Preliminary Acceptance Punchlist
EPC - DPW - Stormwater Section

Project Name:	Urban Collection at Palmer Village
EDARP Filing Number(s):	SF2028
ESQCP Number:	ESQ2138
Attendees:	DPW SW: Dylan Finley, Ben Jones DPW Planning: Developer:
Date of Walk-Thru:	04/25/2023
Walk-Thru Number:	1

**WOCV TRASH SCREEN AND PLATE DETAIL (PLAN)**  
SCALE: 3/4"=1'

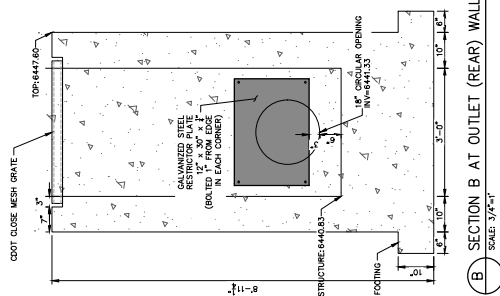
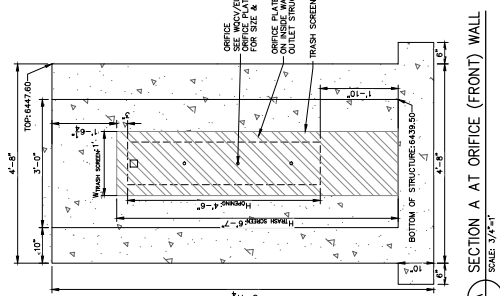
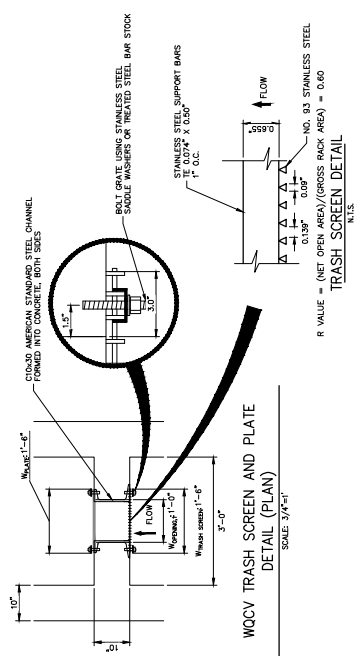
- Clean out sediment and debris from outlet structure and trickle channels. Trash and sediment present.
- Well screen not installed per specification (Pond A page 25) (Pond B Page 29).

- Restrictor plates not installed (Pond A Page 26) (Pond B Page 30).
- Opening in concrete for restrictor plate is installed as rectangular, not circular per plans.

Photo 9: Well screen not installed per specification. (Pond A page 25)

Photo 10: Well screen not installed per specification. (Pond B Page 29)

Photo 11: Restrictor plates missing. (Pond A Page 26)

Photo 12: Restrictor plates missing. (Pond B Page 30)

URBAN COLLECTION AT PALMER VILLAGE
SWALE CROSS SECTIONS
GEC PLANS

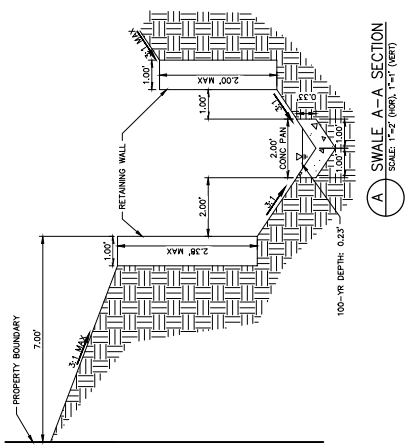
Swales [GEC Page 3]:

- Swale A not completed. Missing retaining wall and concrete pan.
- Swale B & C not completed. Swales are supposed to be 24' wide and clearance onsite is 17' in some areas.

Photo 1: Swale A not completed. Missing retaining wall and concrete pan. (Page 3 of GEC)

Photo 2: Swale A not completed. Missing retaining wall and concrete pan. (Page 3 of GEC) Concrete pan must extend and tie into rip rap run down.

Photo 3: Swale C not completed per specification. (Swales are supposed to be 24' wide and clearance onsite is 17')

Photo 4: Swale B not completed per specification. (Swales are supposed to be 24' wide and clearance onsite is 17')
